**Proposed Himley Village North West Bicester
Middleton Stoney Road Bicester**

**23/00170/REM and
23/00214/REM**

Proposal: Reserved Matters Application pursuant to outline planning permission 14/02121/OUT for Phase 1A (infrastructure comprising two junctions to provide vehicular and pedestrian access into the site from Middleton Stoney Road and two initial sections of internal road) along with the partial compliance of conditions 12 (Building for Life 12), 16 (means of vehicular access), 17 (means of pedestrian/cycle links) and 19 (detailed surface water drainage scheme) for Phase 1A.

TITLE MIDDLETON STONEY ROAD, MAIN SPINE ROAD JUNCTION. GENERAL ARRANGEMENT SHEET 1	
HYDROCK PROJECT NO. C-27141-C	SCALE @ A2 1 : 500
STATUS DESCRIPTION INFORMATION	STATUS S2
DRAWING NO. (PROJECT CODE-ORIGINATOR-ZONE-LEVEL-TYPE-ROLE-NUMBER) 27141-HYD-XX-XX-DR-D-0001	REVISION P02

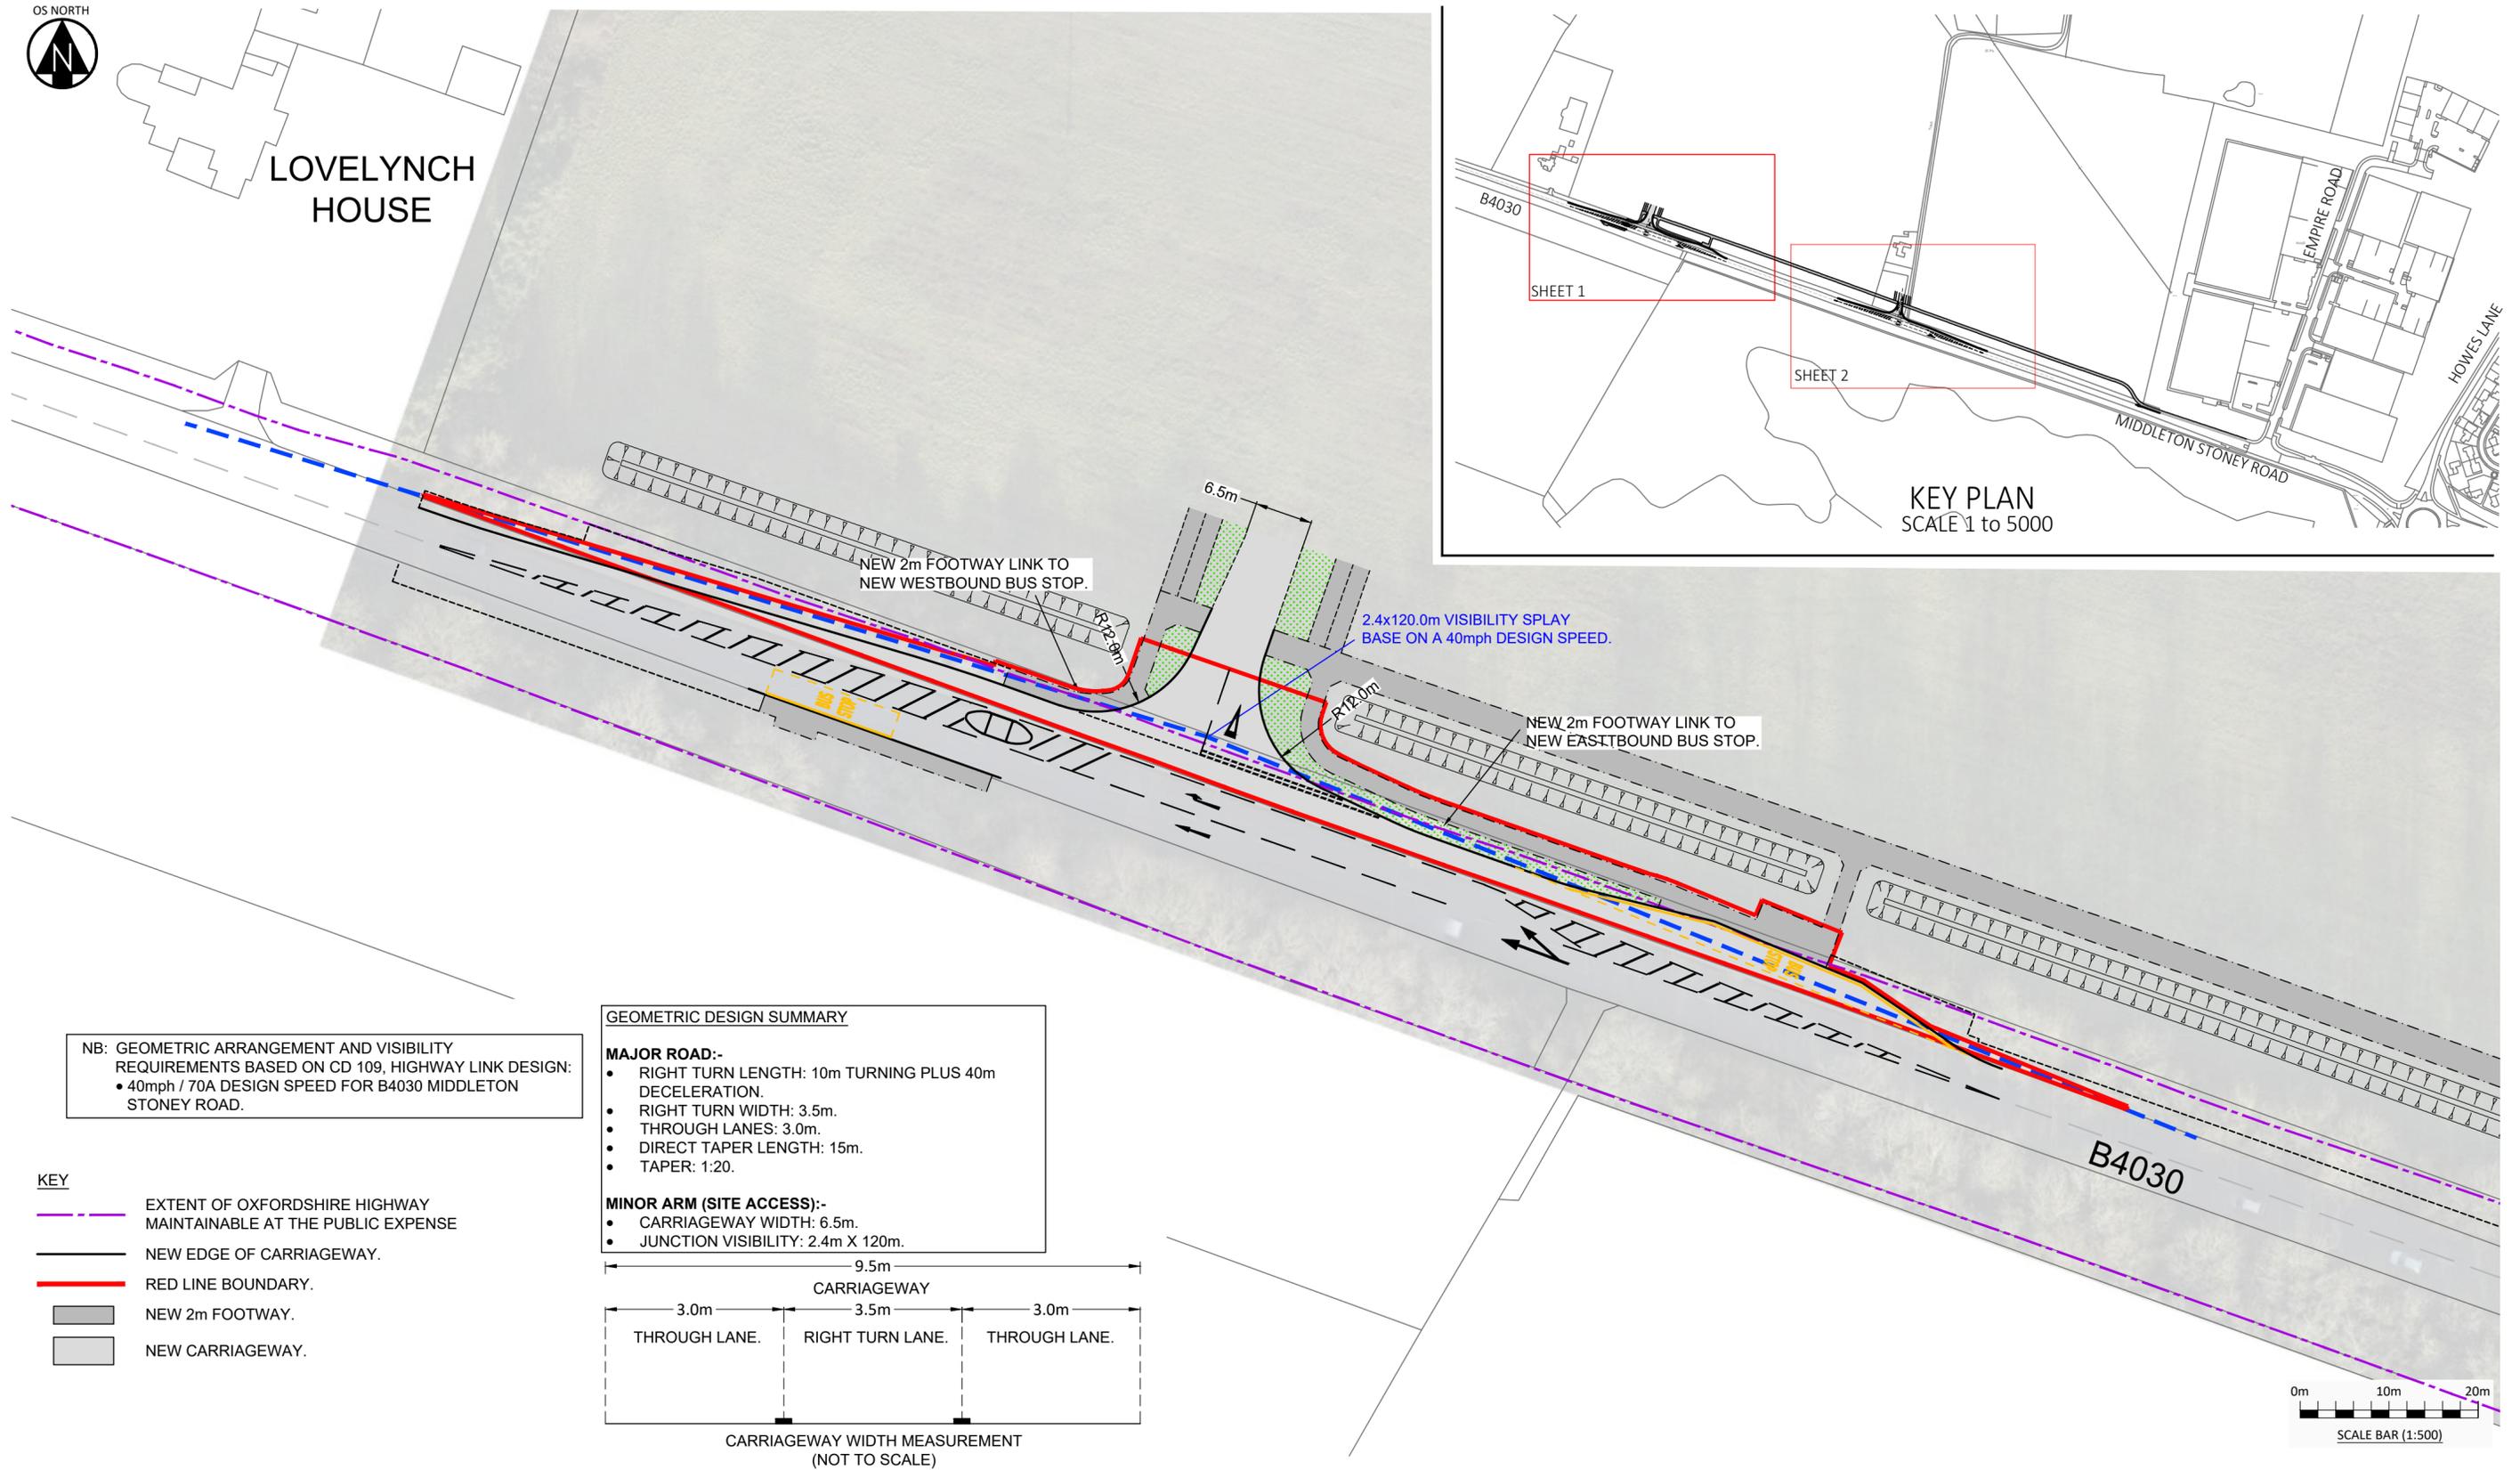
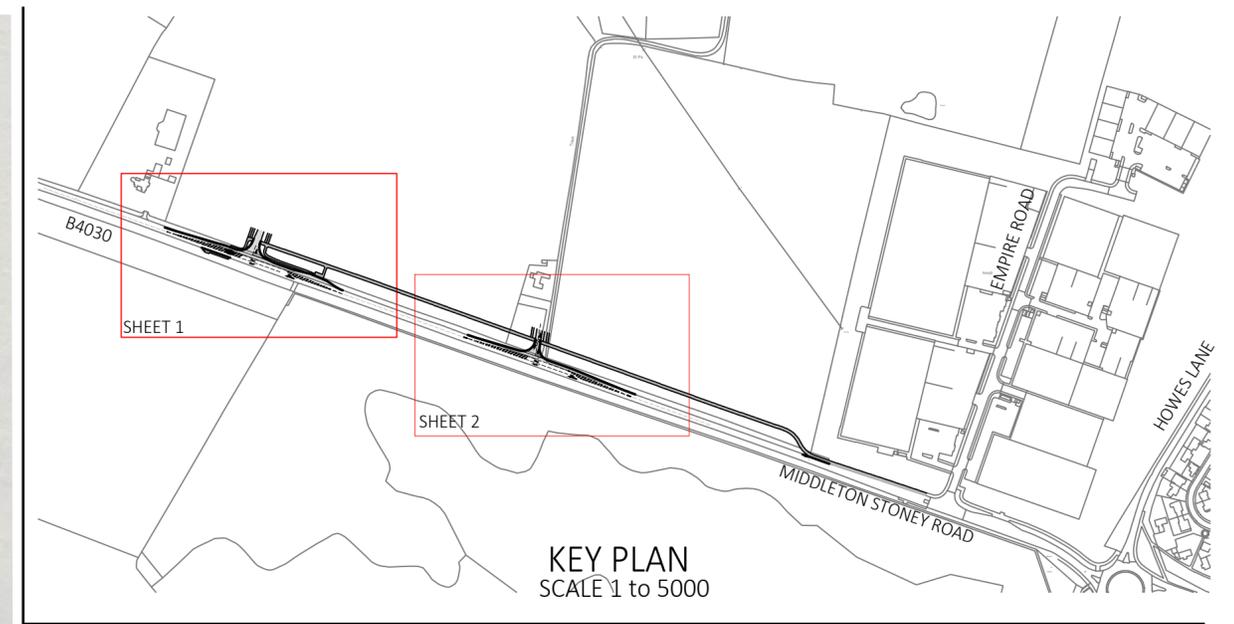
Make the following comments: Concern that the junctions show a cycle path on only one side of the spine road in conflict with OCC standards and uncontrolled crossings for cyclists and pedestrians at the junctions will not prioritise them as highway users. *[Officer Note: The outline planning permission was granted prior to LTN1/20 and the foot/cycle paths on the Middleton Stoney Road were agreed as part of the S106]*

- 8.6. Secondly, they state that the proposed cycleway and footpath from Middleton Stoney to Bicester (required as part of the Heyford development) should be represented on the plans. A more detailed plan has been provided by the applicants to show that footpath and cycle paths will be provided for this development along the Middleton Stoney Road to connect it to proposed and existing bus stops in accordance with Schedule 18 of the S106 for the outline permission. This is considered to be appropriate for these planning applications and requirements of other planning permissions schemes cannot reasonably be applied to this proposal.

TITLE  
MIDDLETON STONEY ROAD,  
SECONDARY ROAD JUNCTION.  
GENERAL ARRANGEMENT  
SHEET 2

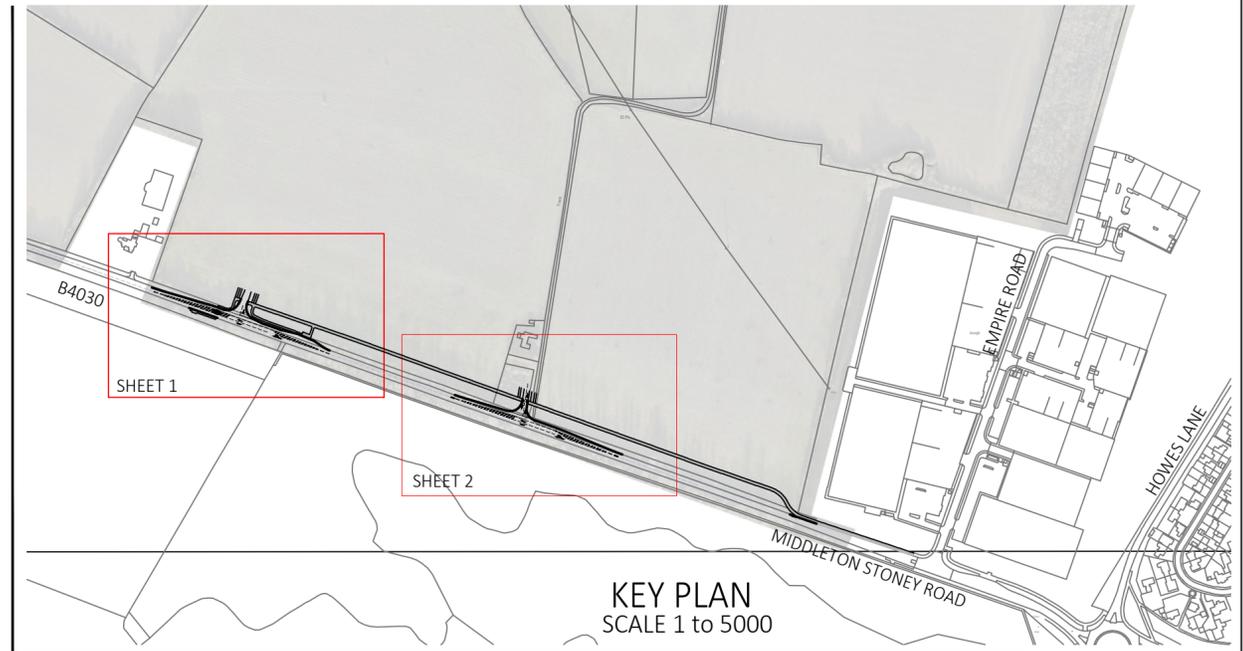
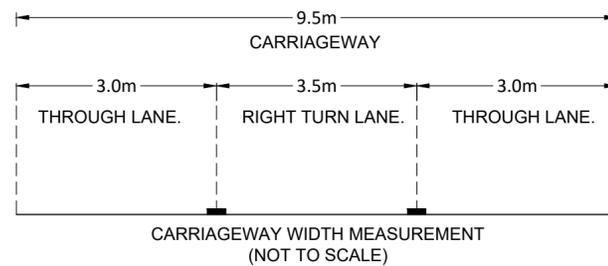
Local Highways – No objection. They originally objected to the application on the grounds that the secondary access was not sufficiently wide to allow 2 buses to pass. They have subsequently removed this objection on the grounds that the bus service would not need to use the secondary road/access even for a temporary period and that adequate public transport provision could be achieved for an interim period from the service on Middleton Stoney Road prior to buses entering the site via the primary access road and the adjoining Axis J9 development. Confirm that they have no objections relating to partial compliance with conditions 16 and 17.

TITLE MIDDLETON STONEY ROAD, MAIN SPINE ROAD JUNCTION. GENERAL ARRANGEMENT SHEET 1	
HYDROCK PROJECT NO. C-27141-C	SCALE @ A2 1 : 500
STATUS DESCRIPTION INFORMATION	STATUS S2
DRAWING NO. (PROJECT CODE-ORIGINATOR-ZONE-LEVEL-TYPE-ROLE-NUMBER) 27141-HYD-XX-XX-DR-D-0001	REVISION P01

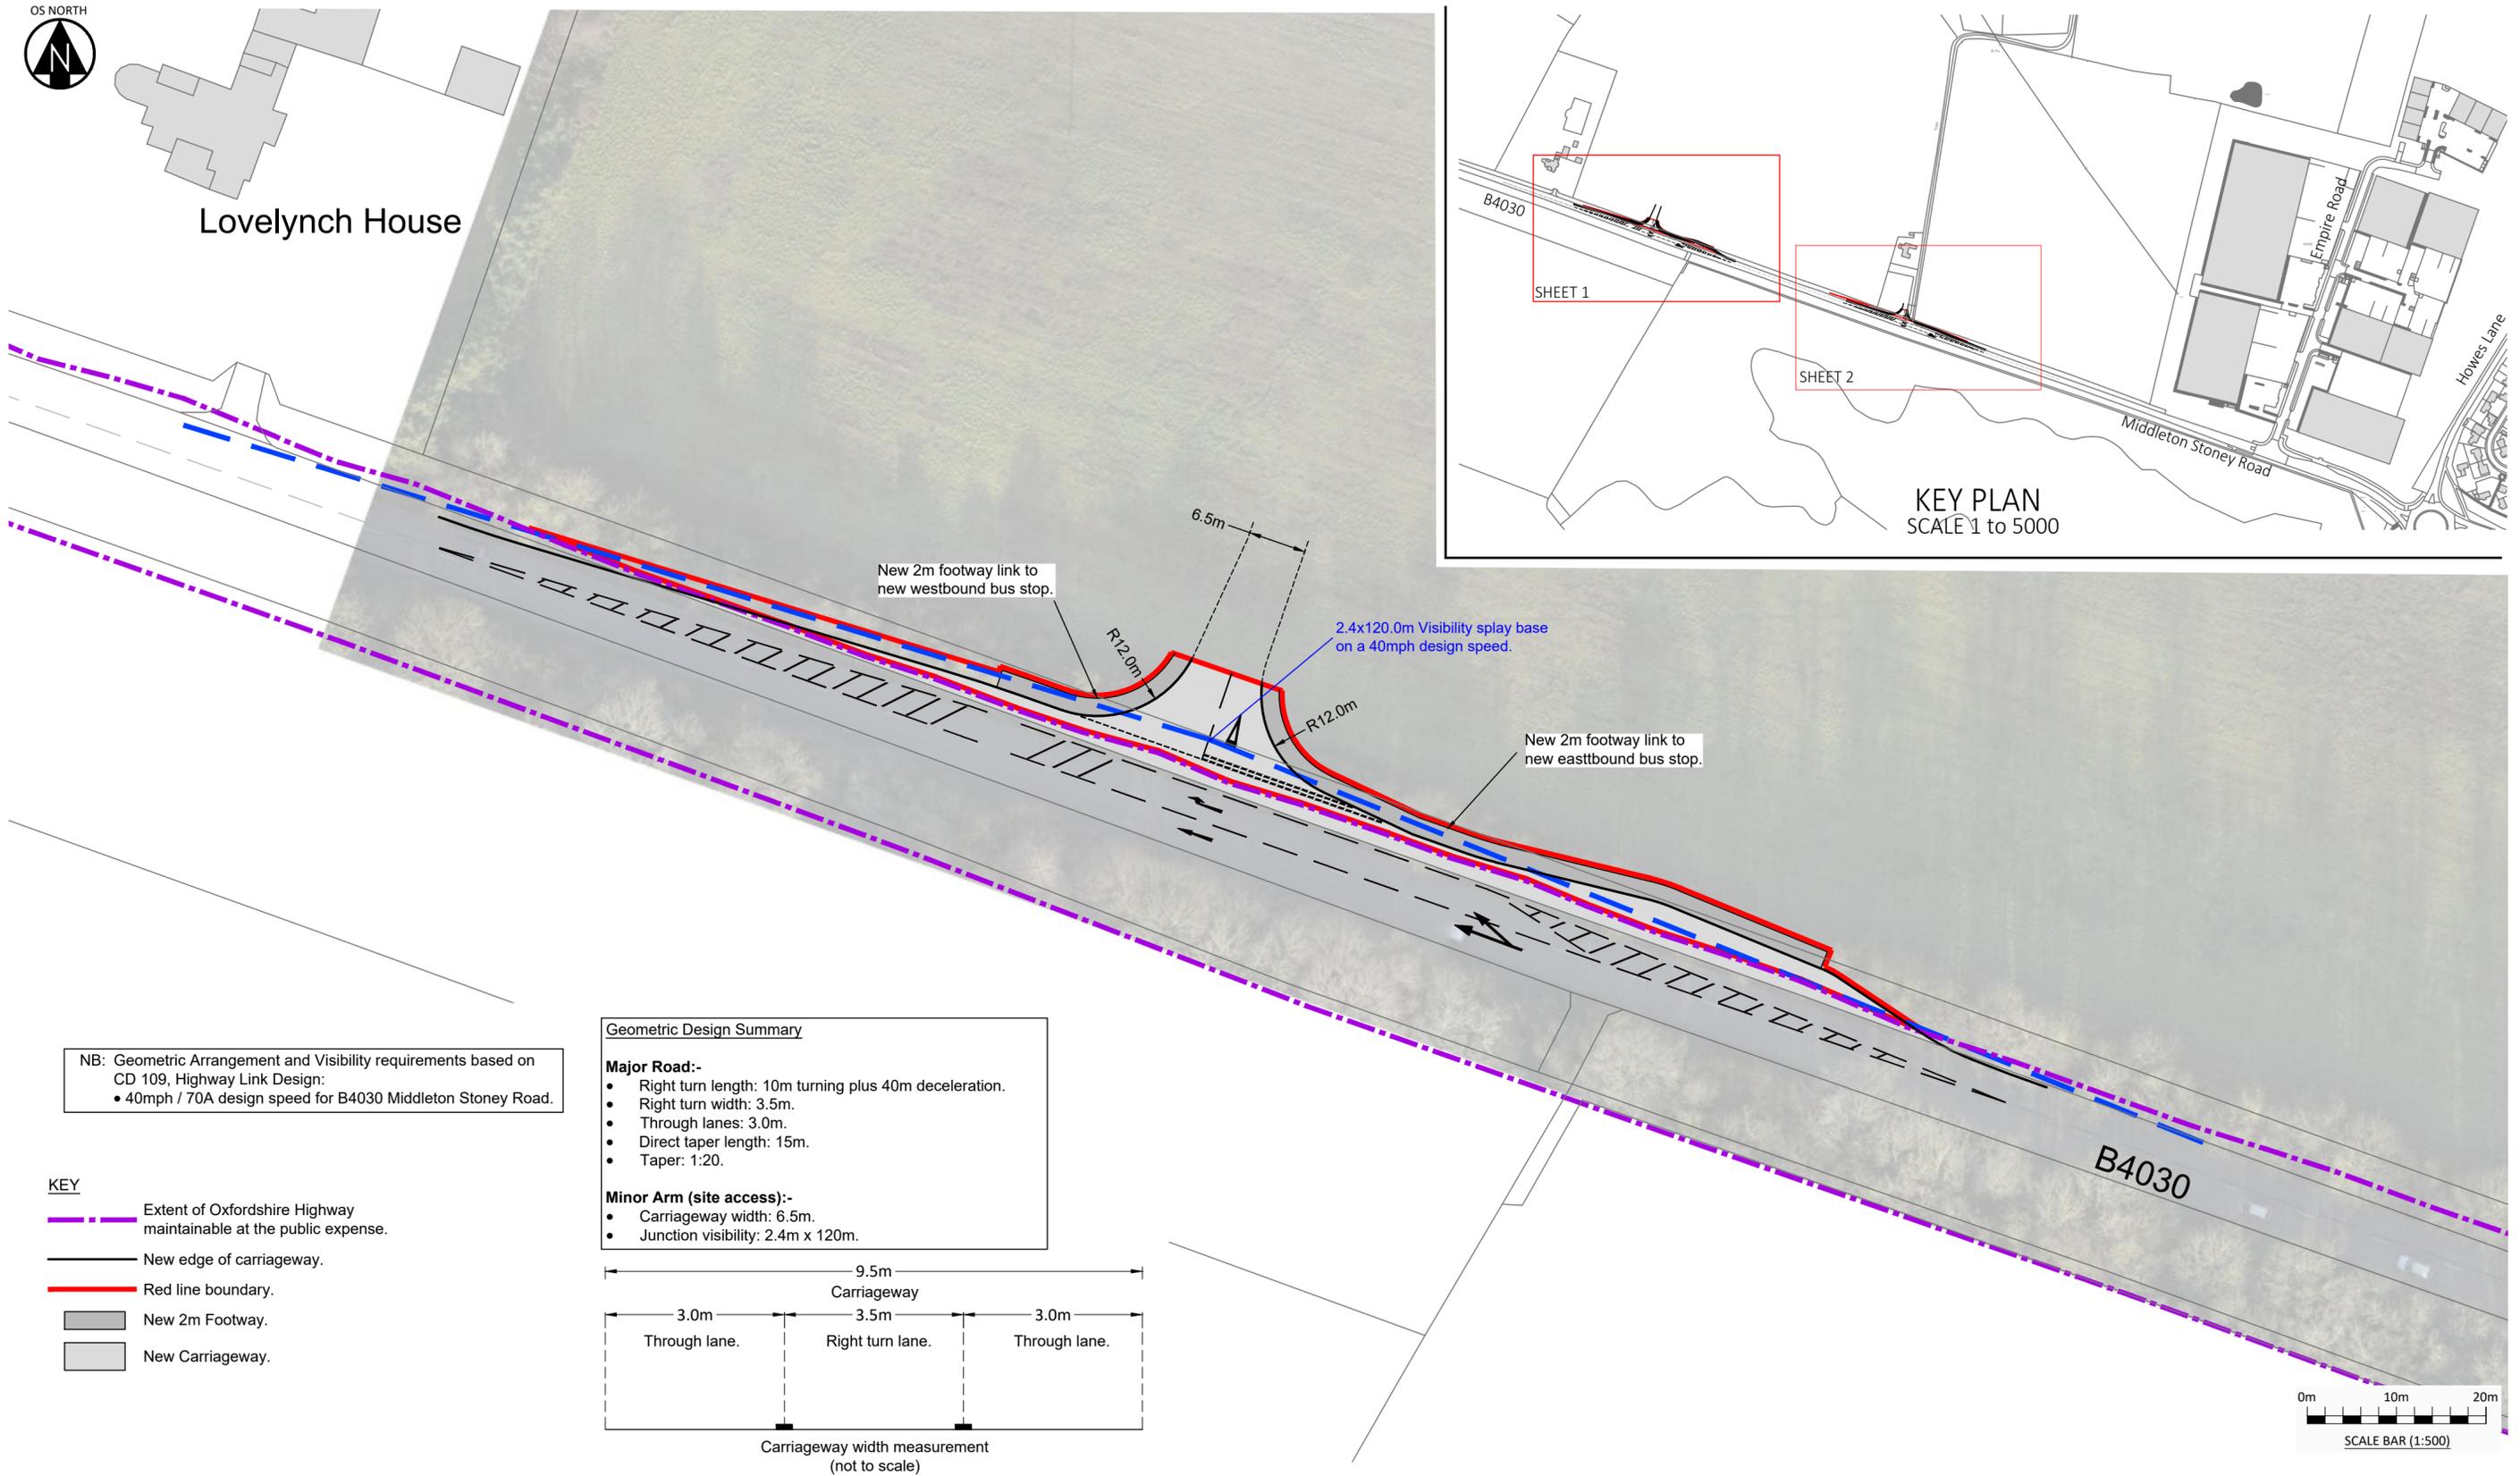
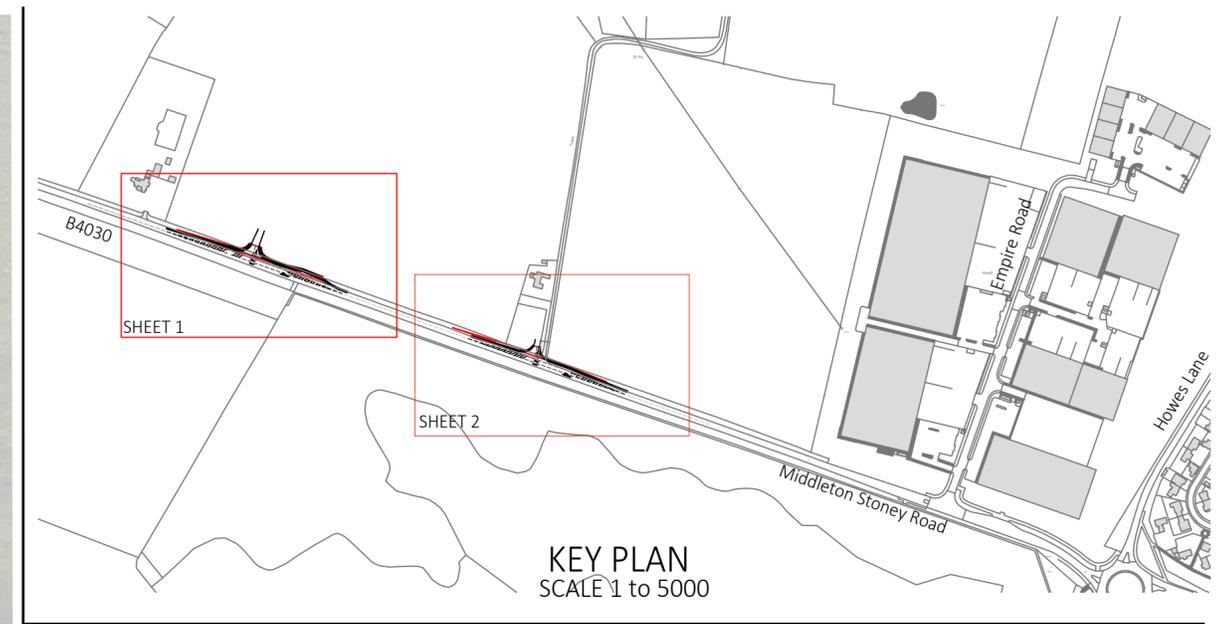
agreement. The cycle and pedestrian paths along the spine road and the crossing facilities are all outside of these reserved matters applications (beyond the red line) and therefore subject to consideration under future reserved matters but additional information provided by the applicant demonstrates that they can comply with the current standards (i.e. segregated and on both sides).]
